DECISION DELEGATED TO DEVELOPMENT MANAGER

Application No: H16-1169-18 **Applicant:** Mr S Willson

Proposal: First floor extension above garage with single-storey rear and side extension

Location: 41 Claudette Avenue Spalding

Drg No 2945 / 08 rev B

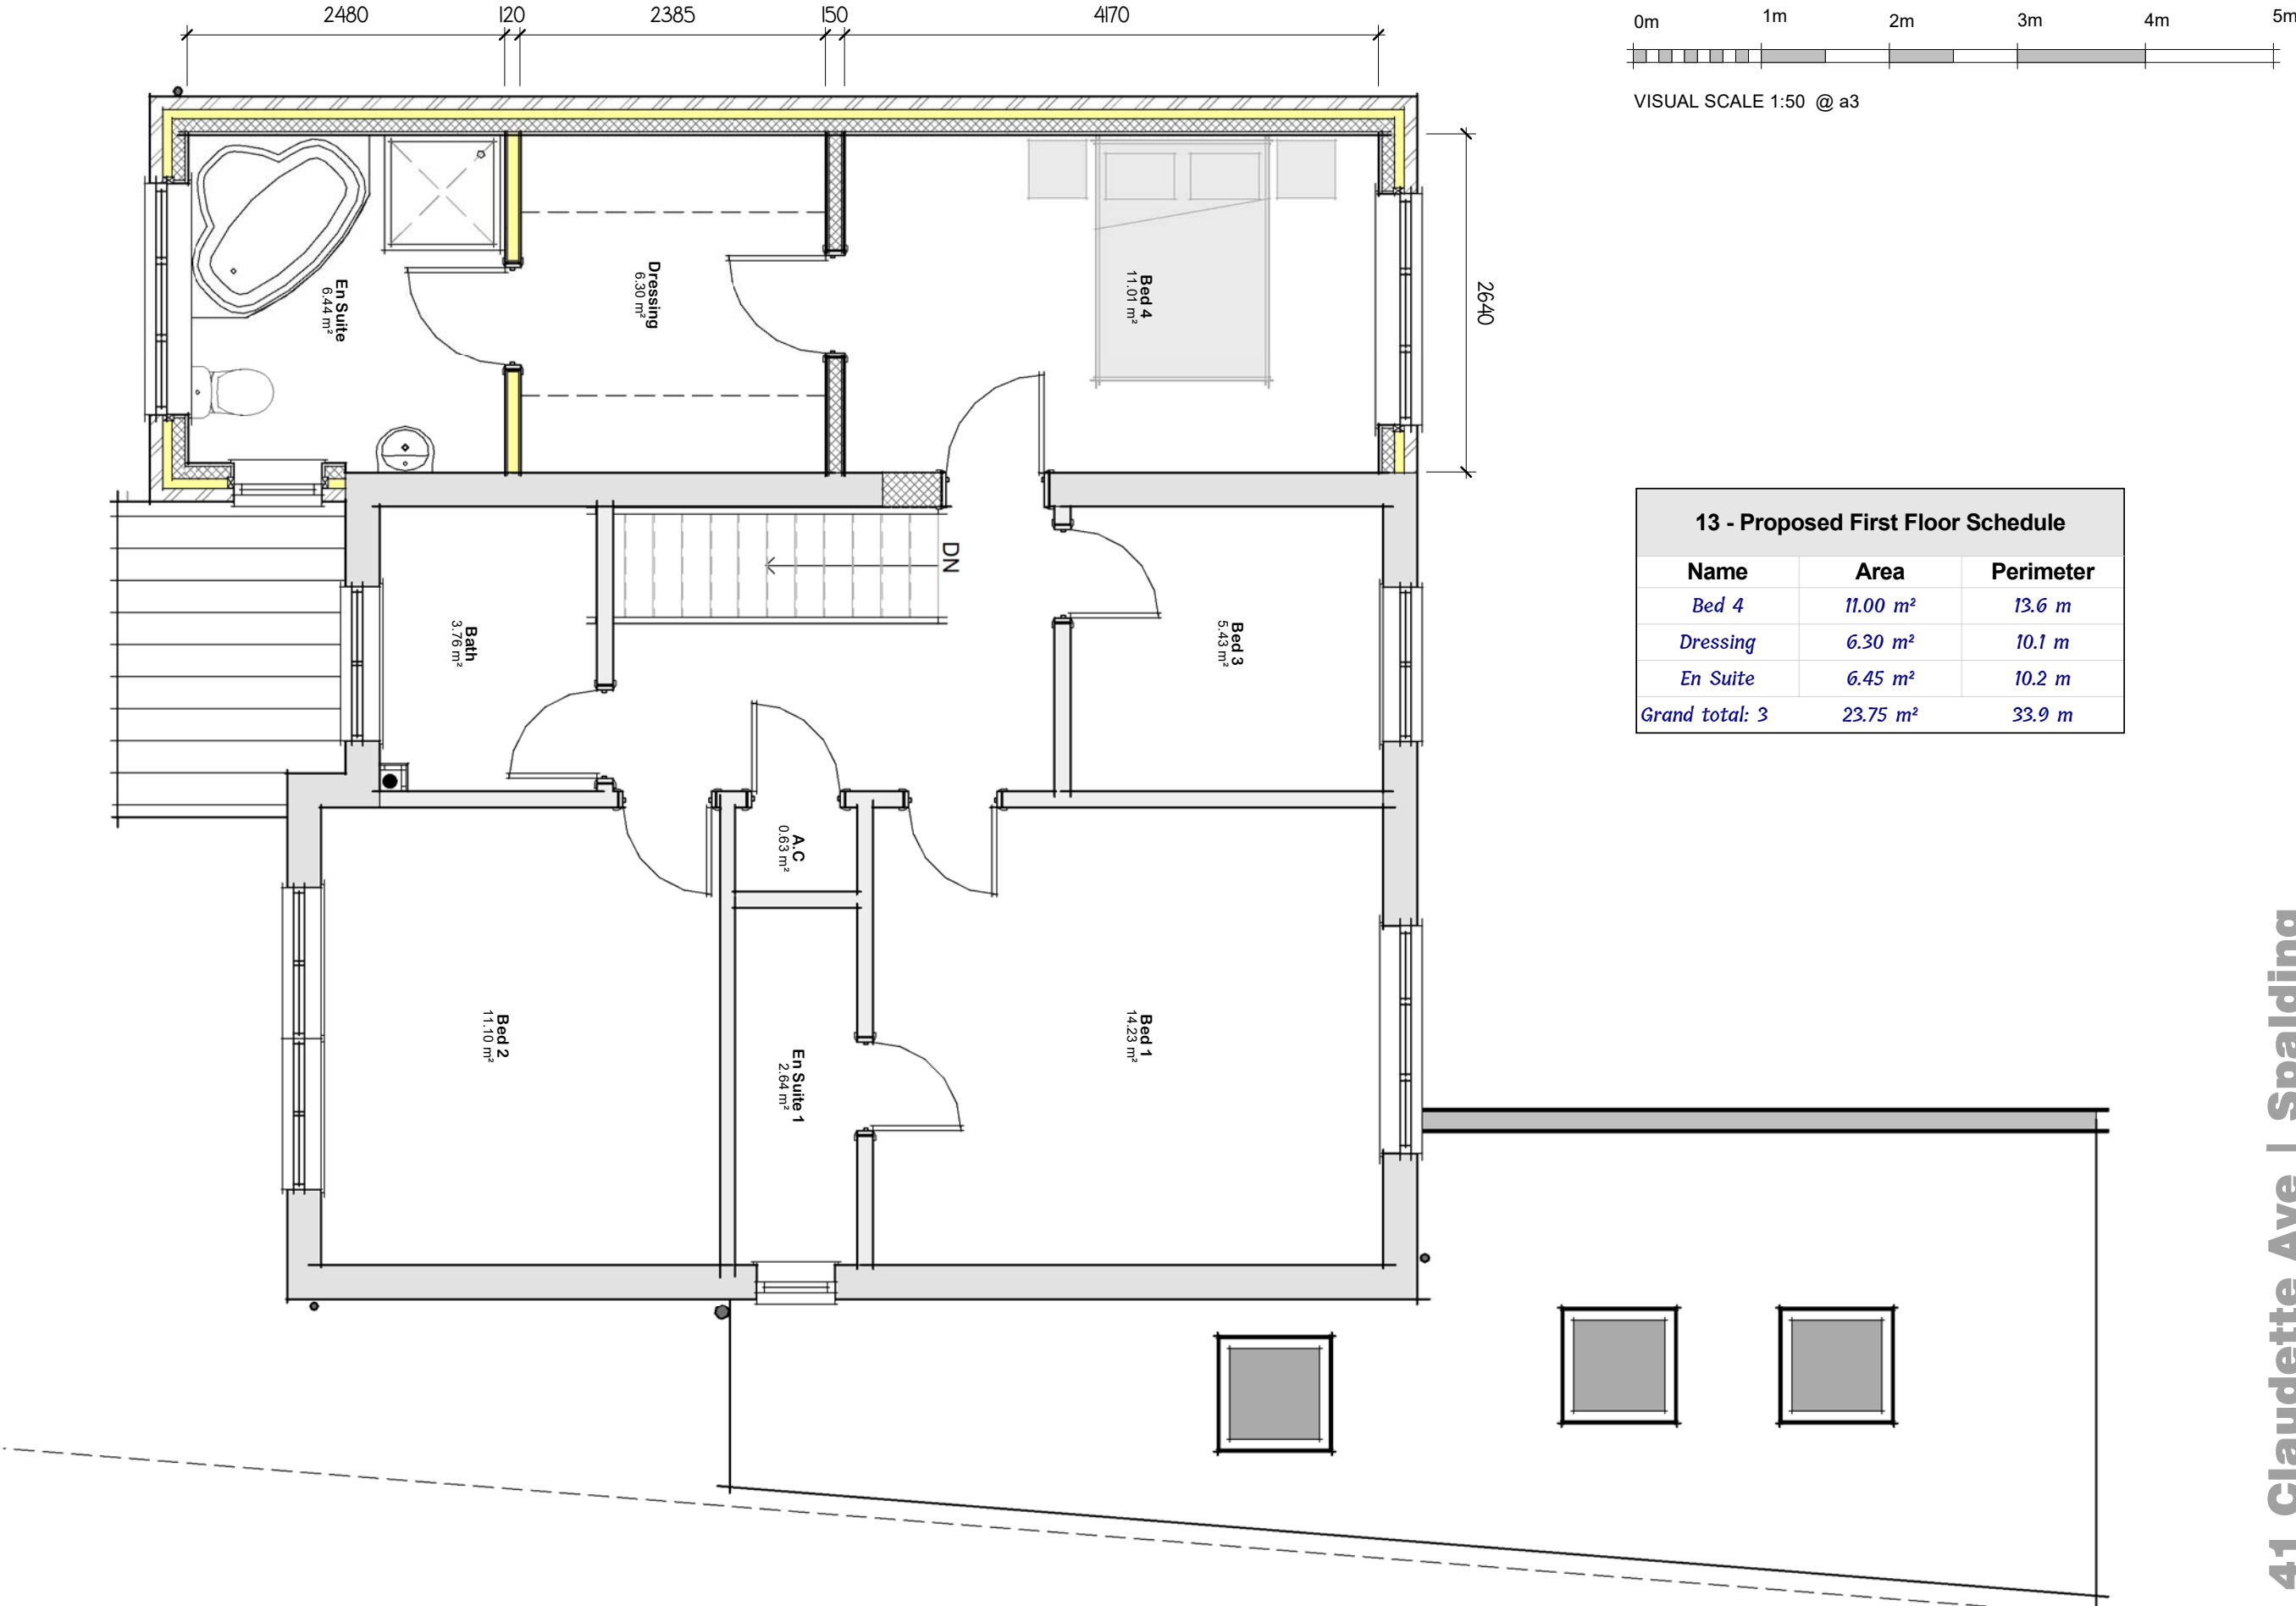
The first-floor extension would be erected following the existing footprint on the ground floor. The massing would be therefore commensurate with the host property and its bulking would not affect the adjacent dwelling at No. 39. There are no windows on the opposing elevation.
